Submission No.			131		
Organisation Name or Name of Submitter			Irish Life Assurance plc. (70 St Stephens Green) - represented by Waterman Moylan		
Item No.	Section Ref.	Page No.	Observation Statement	TII Response	
Re: Railway (Metrolink-Estuary to Charlemont via Dublin Airport) Order 2022, 70 St Stephens Green (formally known as Hainault House Nos. 69-71 St. Stephens Green, Dublin 2)					
1	Submission 1	2	<p>The route selection including horizontal alignment, vertical alignment and depth of MetroLink below ground in the area between Chainage 18+600 and Chainage 18+700 should be reviewed by NTA / TII to satisfy themselves and to ensure that</p> <p>(a) MetroLink does not cause structural damage to the foundation system supporting our client’s building which comprises a mixture of CFA piles (some extending c.14.0m below ground level) and pads foundations which are founded on the competent rock.</p> <p>(b) MetroLink does not cause structural damage to our client’s building at the basement level. The basement structure forms the waterproof envelope to our Clients building and any damage would result in the ingress of water into the basement.</p> <p>(c) MetroLink does not cause damage t

### Figure 14.2 Groundborne Noise from Tunnel Boring Machine Sheet 7 of 7

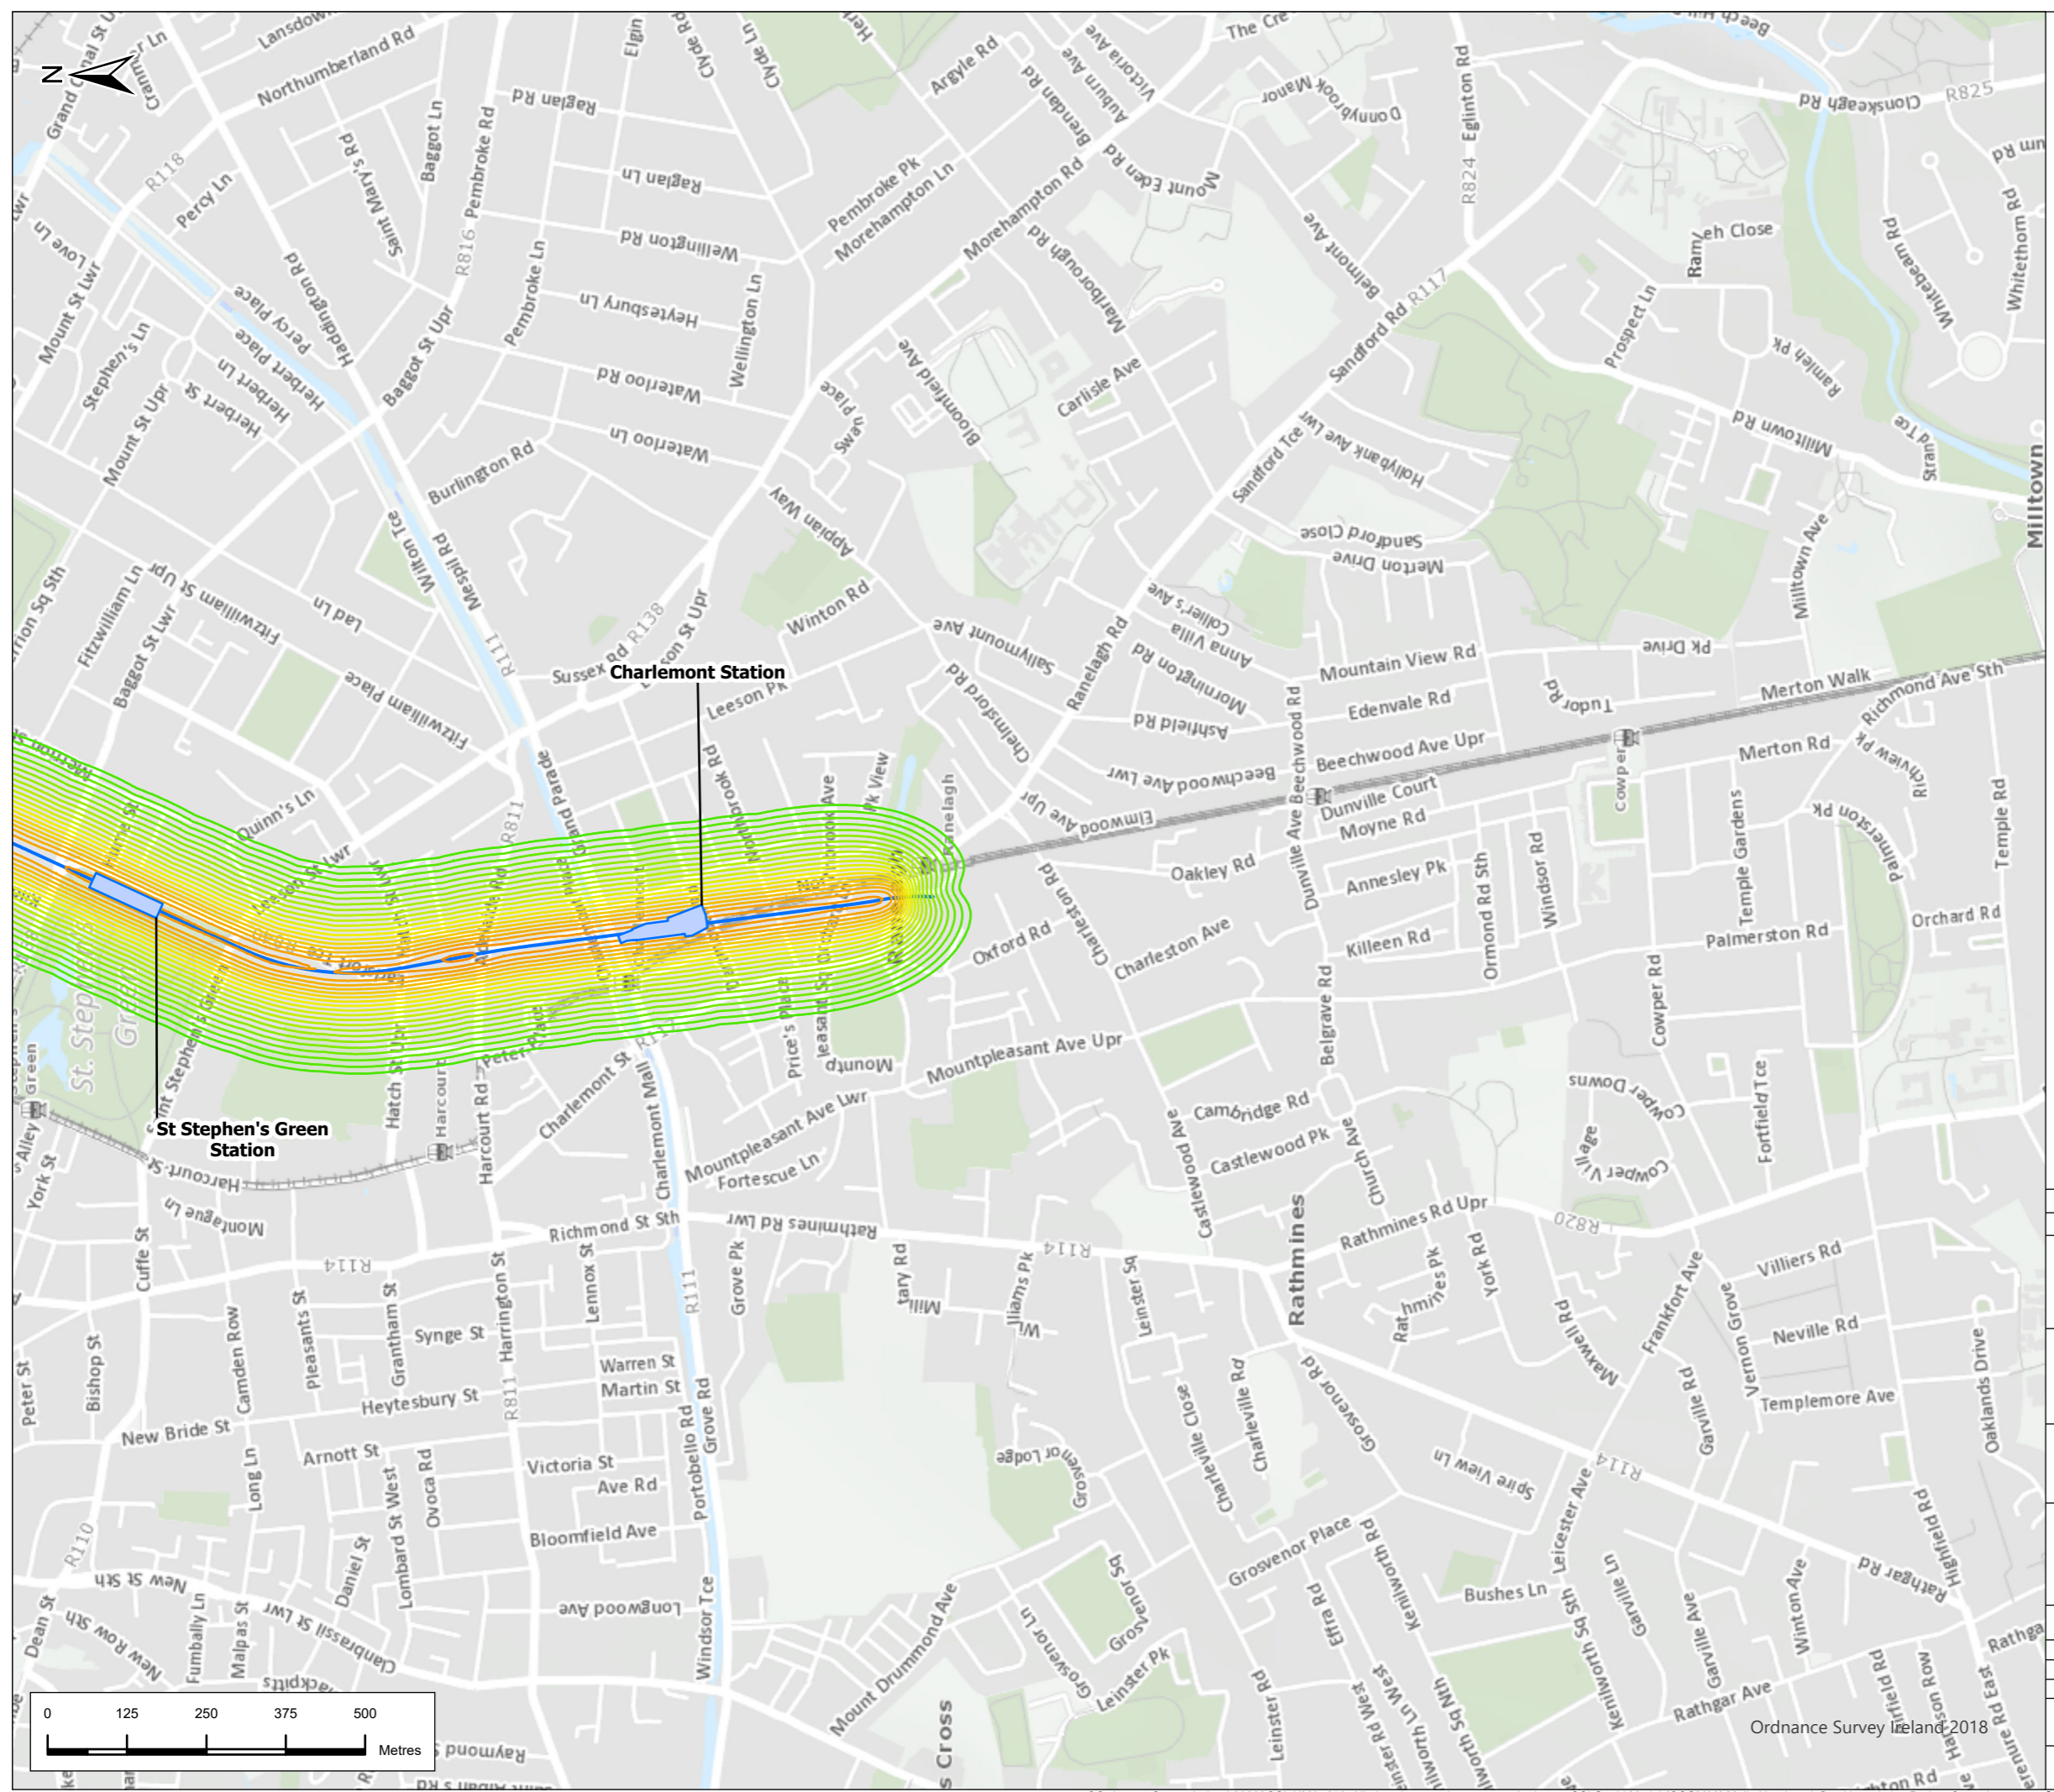
2	Submission 2	2	<p>a) Metrolink has assessed the "Groundborne Noise from Tunnel Boring Machine" and presents its findings on drawing no. ML1-JAI-EIA-ROUT-XX-DR-Y-14009 (a copy is attached to this submission). This drawing indicates MetroLink will generate an additional 50db directly under the location of our client's building which is unacceptable.</p>	<p>EIAR Appendix 14.5 Groundborne Noise and Vibration Blasting Modelling Results presents predicted groundborne noise and vibration levels during the construction and operation phase of the project. The prediction of groundborne noise during TBM passage for 70 St Stephen's Green building is 49 dB LASmax, which is above the 45 dB LASmax threshold, resulting in a temporary significant impact on the building for the limited duration of TBM passage (less than 2 weeks).</p> <p>Unfortunately, there are no effective methods available to reduce groundborne noise or vibration from the TBM at source. As a result, the principal mitigation measure to minimise effects on 70 St Stephen's Green will be advance public consultation and stakeholder engagement to reduce the significance of groundborne noise effects during construction so that your client is prepared for the passage of the TBM and resultant elevated noise levels. TII will accept and consider applications for additional measures on a case-by case basis, in accordance with its Noise and Vibration Mitigation Policy (see Appendix A14.6 of the EIAR).</p>

Drawing No.	ML1-JAI-EIA-ROUT_XX-DR-Y-21149	Rev	P02
-------------	--------------------------------	-----	-----

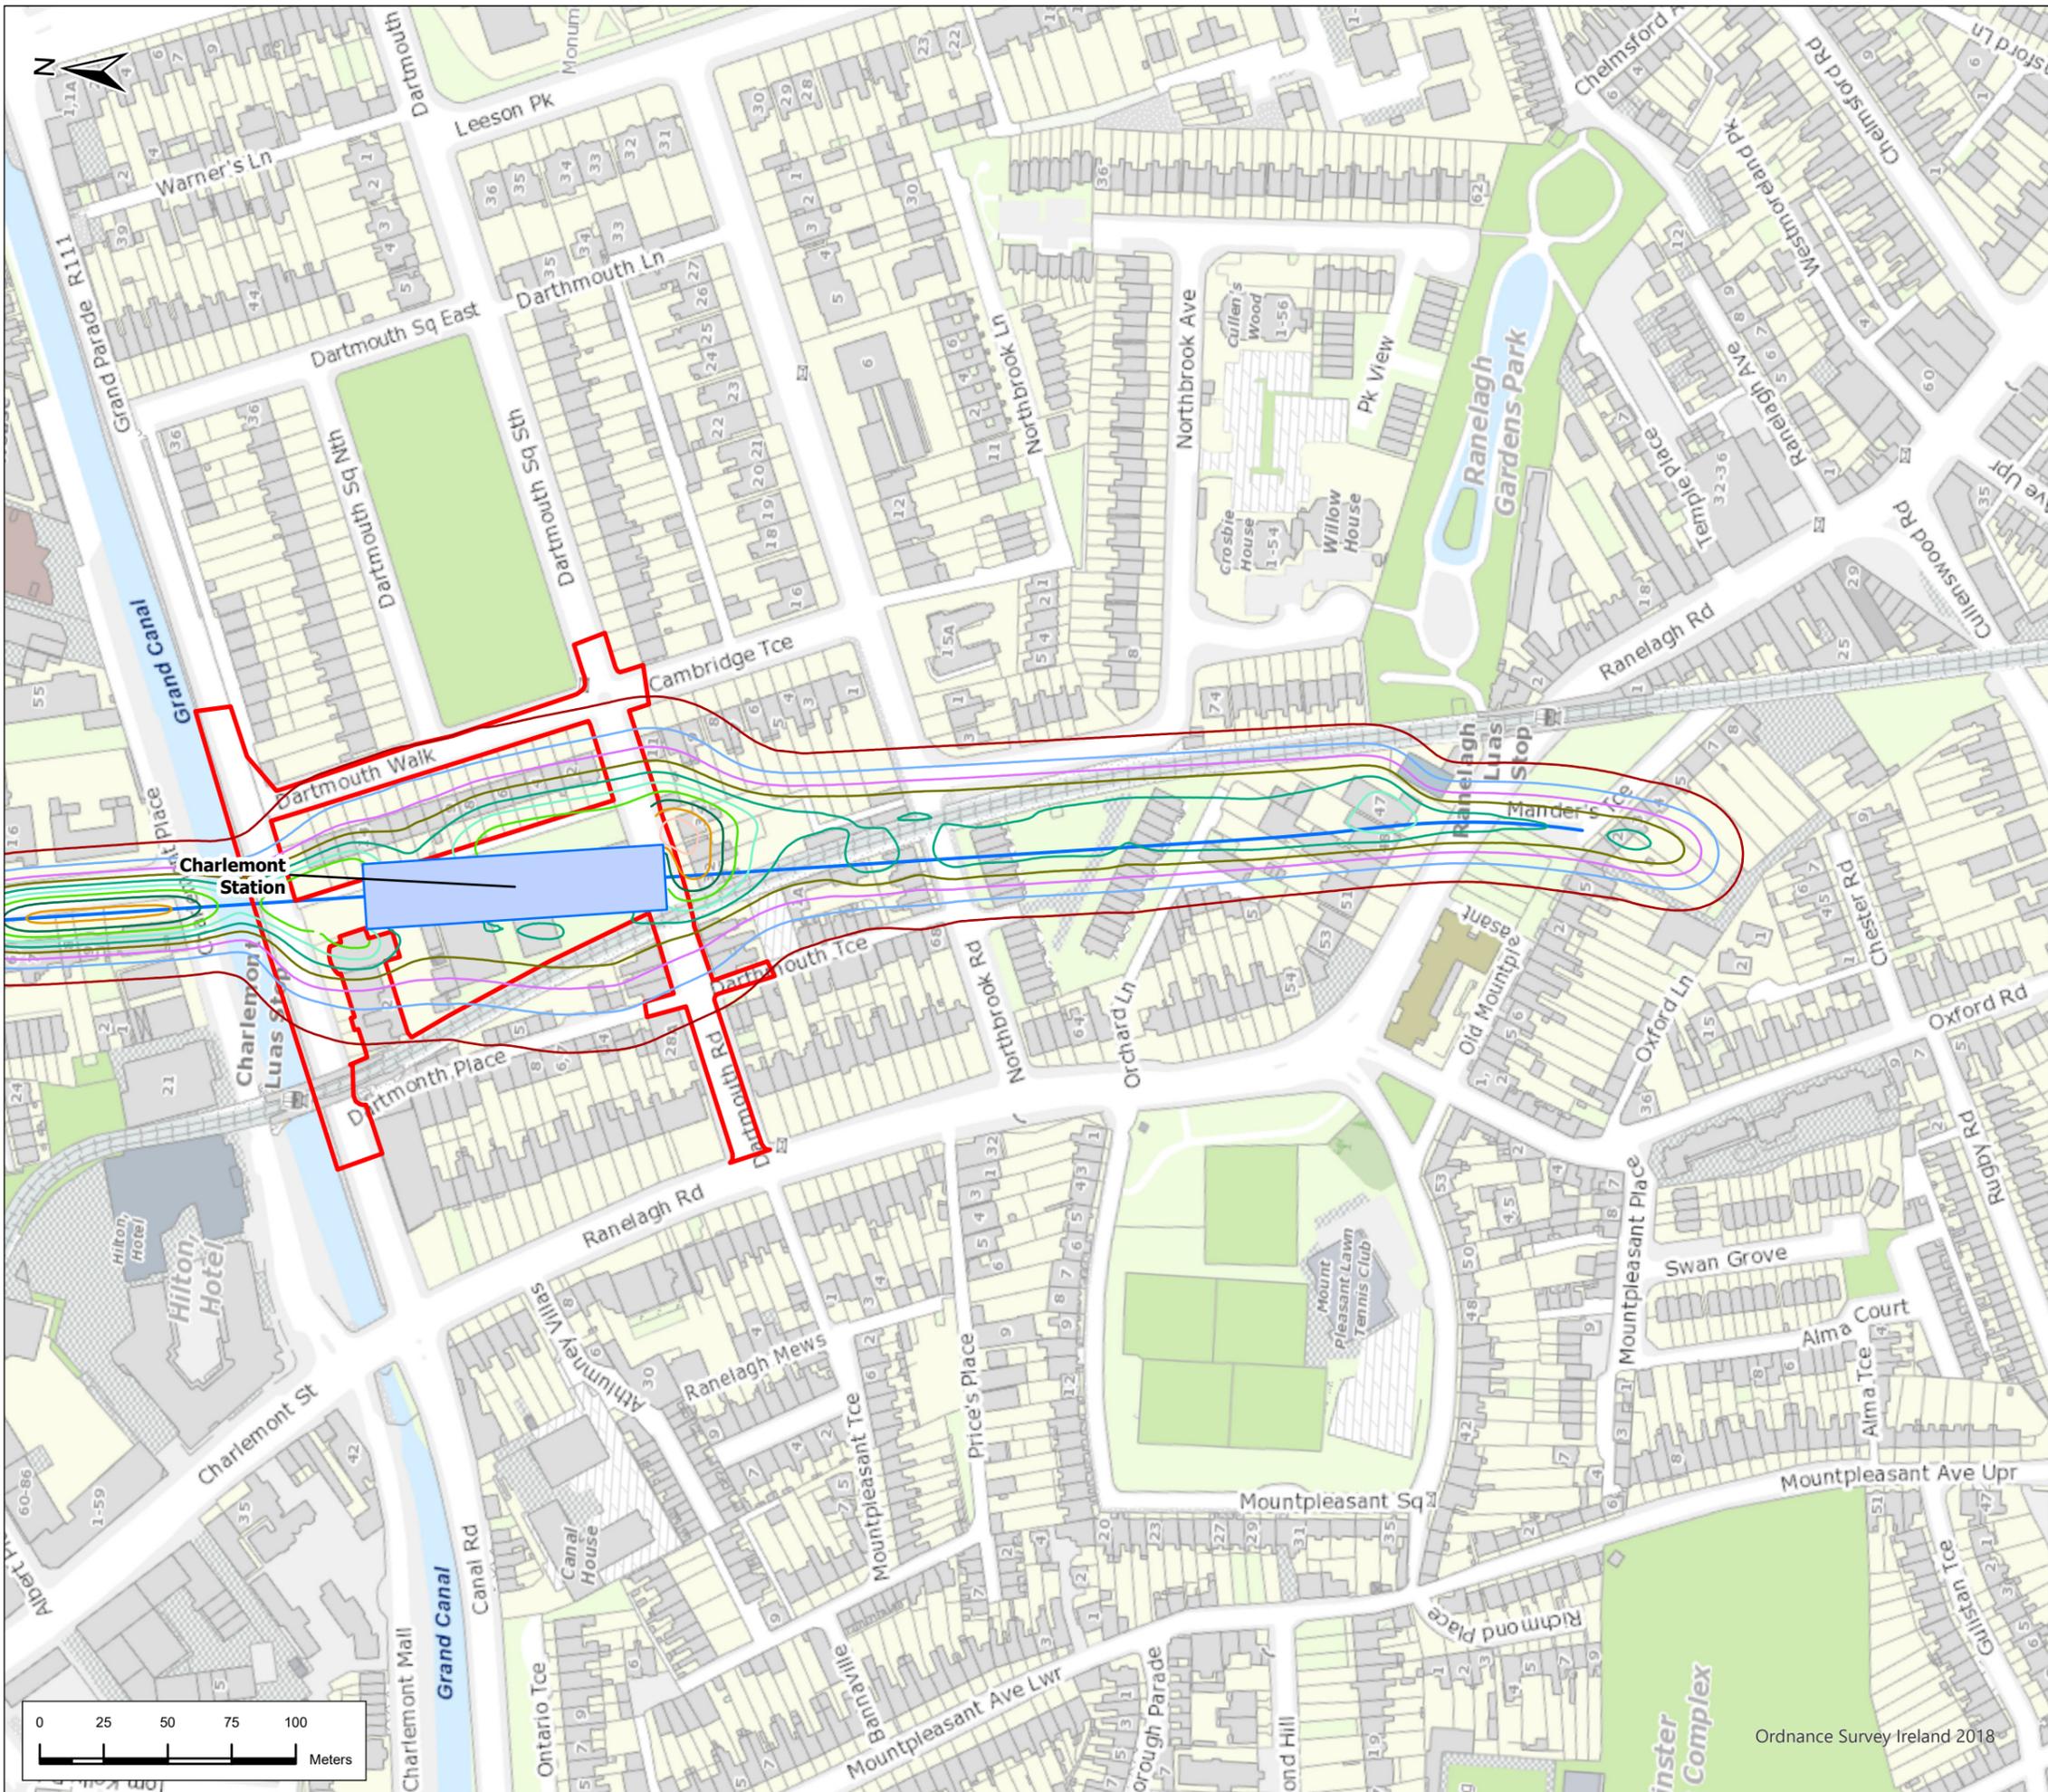
3	Submission 2	2	<p>b) Metrolink has assessed the predicted "Settlement" and presents its findings on drawing no. ML1-JAI-EIA-ROUT-XX-DR-Y-21149 (a copy is attached to this submission). This drawing indicates MetroLink will be causing a 15mm settlement directly under the location of our client's building which is unacceptable. Settlements of this magnitude cannot be accommodated by the building's structure and will cause damage to foundations; basement; superstructure; facade and internal finishes. As previously stated the basement structure forms the waterproof envelope to our client's building and any damage would result in the ingress of water into the basement.</p>	<p>The eastern boundary of 70 St Stephens Green is just outside the 10mm contour and no structural impacts are assessed. However, despite being just outside the 10mm contour, TII will implement a Phase 3 assessment due to the building features noted in this response. Refer to response (1).</p>
